**REQUEST**

Current Zoning: R-6MF(CD) (multi-family residential, conditional)  
Proposed Zoning: UR-2(CD) (urban residential, conditional)

Approximately 0.30 acres located on the south side of Hoskins Road and west side of Gossett Avenue.

The petition proposes to adaptively reuse the existing building onsite with six multi-family dwelling units at a density of 20 units per acre. The site was originally an accessory building to Hoskins Mill.

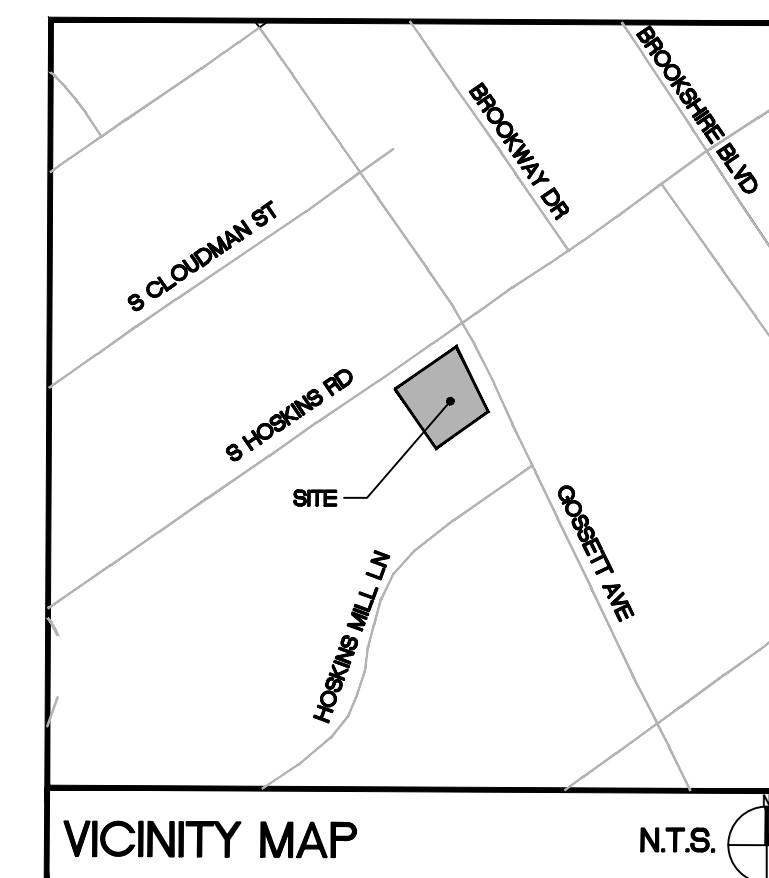
1. Please provide dimensions for the existing sidewalk along Gossett Ave. The existing sidewalk must be a minimum of 6' to be used for UR zoning.
